Application No. 2023/90112. Listed Building Consent for partial demolition of Listed Building to facilitate refurbishment and extension of the George Hotel to form 90+ room hotel.

Comments made on behalf of Huddersfield Civic Society.

Proposed Elevation B
1:50

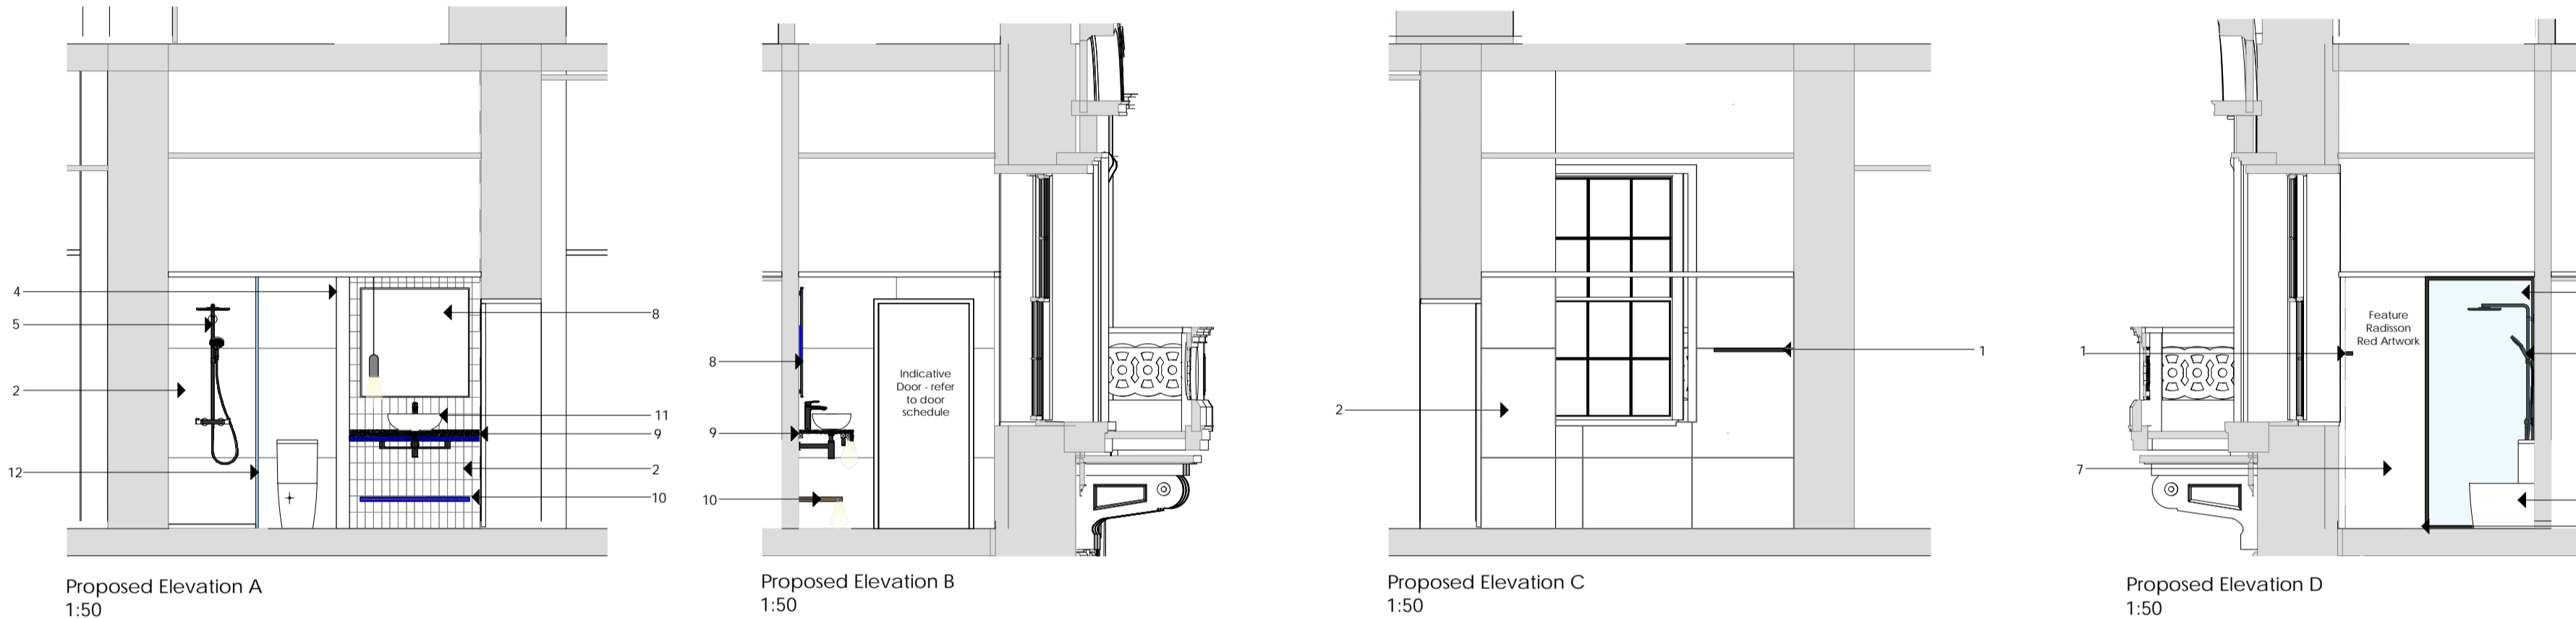
Block B: This will be highly visible from the Grade 1 listed station. In our opinion it requires further design resolution, particularly the left side of this extension which loses the balance and references to the historic/architectural context of its surrounds. Every area of the building has been justified apart from this end corner. Page 25 (Visual 3) of the Design and Access Statement shows the view from coming out of the train station – where block A meets Block B. This is acceptable, but the transition to the corner is not fully considered, lacks the rhythm and permanence of its Italianate neighbours and requires re-modelling.

Block C: The John William Street elevation to this extended wing lacks the strength and formality of the buildings it faces. It is felt that some consideration should be given to reinforcing this relationship. Greater emphasis should be given to the architectural and historic context of adjacent buildings perhaps by the application of subtle detailing as indicated below.

Connection to the relative formality of the existing wing that it adjoins could perhaps be achieved by replicating the size of openings of the bay to include those within the lightwell on the chamfered corner and continuation of horizontal elements, particular in the form of a modern cornice above the second floor level and possibly string courses between floors. These would help strengthen massing and help acknowledge associations with the neo-classical features of adjacent mid-C19 buildings plus help reduce the visual impact of the upper floors with their metal cladded frontages.
